National Infrastructure Planning  
Temple Quay House  
2 The Square  
Bristol, BS1 6PN

Our Ref: EN010137

**Application by Mona Offshore Wind Limited for an Order Granting Development Consent for the Mona Offshore Wind Farm**

**Request for further information**

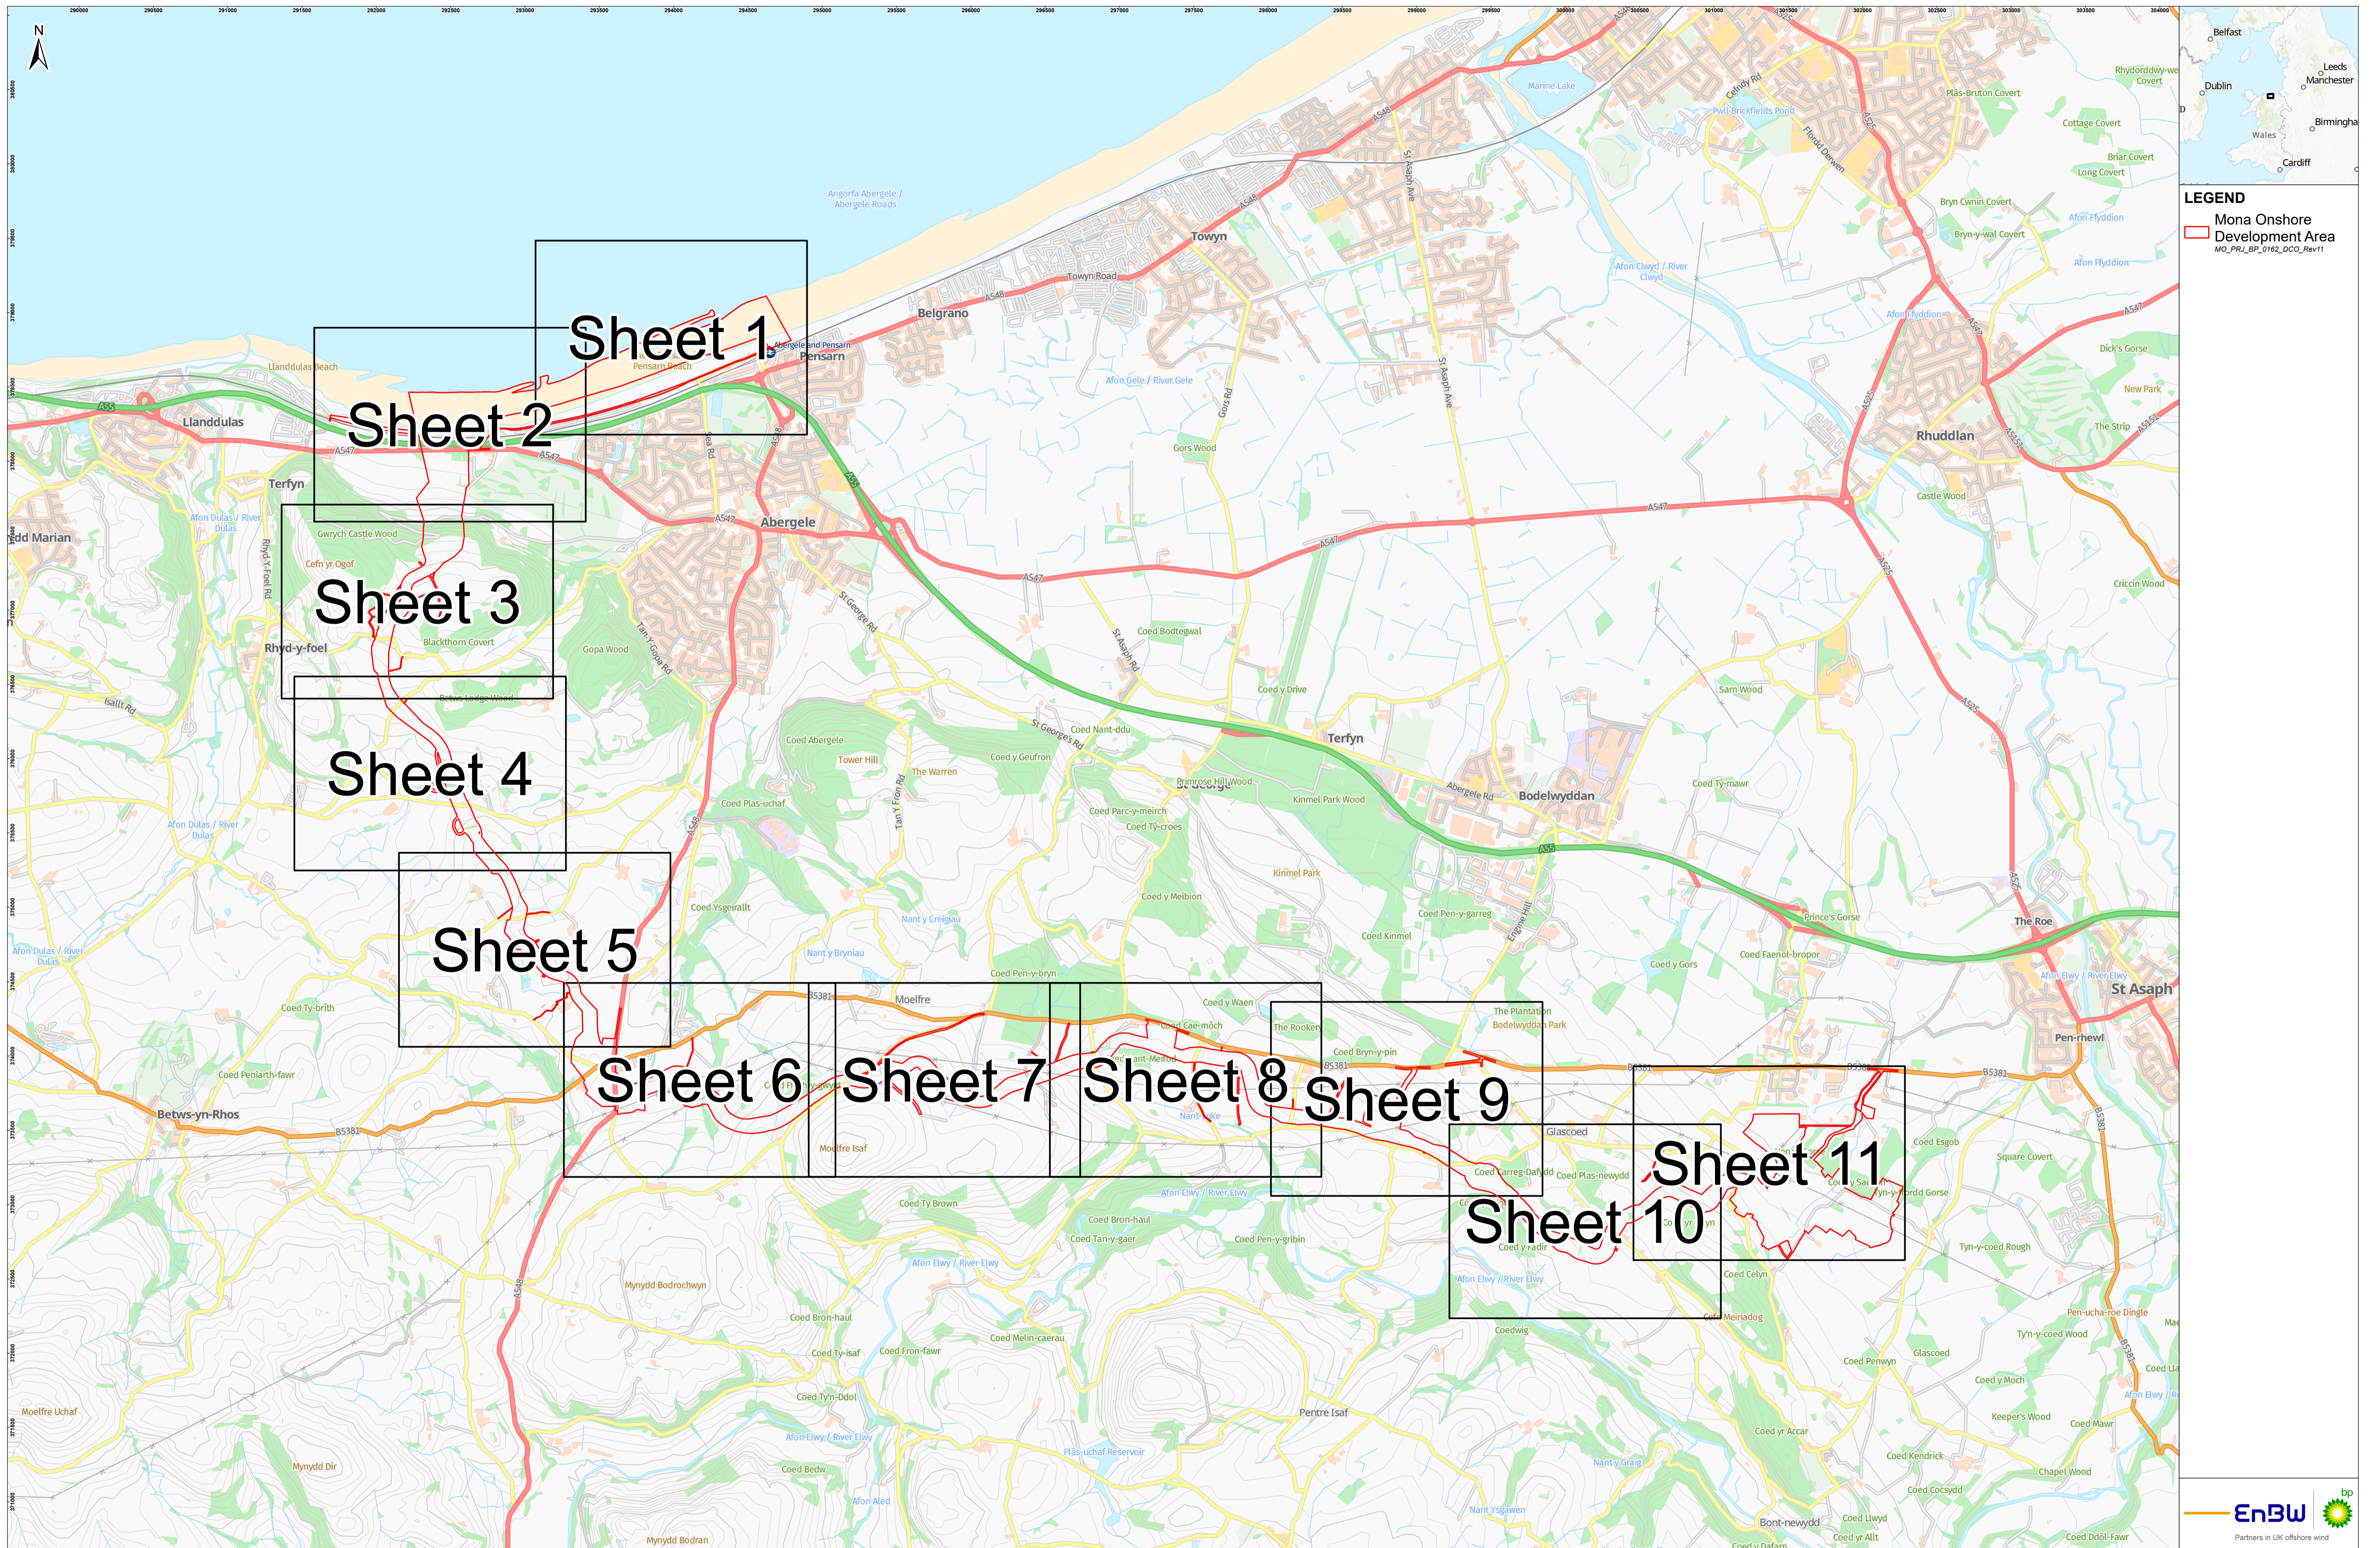
In Table 4.1: Outline PRow management measures of your Outline Public Rights of Way Management Strategy [REP6-064], in respect of the Wales Coast Path and NCR 5 you say that '*No PRow management measures required. Trenchless techniques will be used at this location to avoid requirements for the temporary stopping up of these PRow*'.

Please clarify the contradiction between this cited evidence and your conclusion in paragraph 1.6.4.4 of your Planning Statement. Does that paragraph need to be changed in respect of recreational use? If it correctly represents your position, then please signpost the associated evidential basis to support that conclusion.
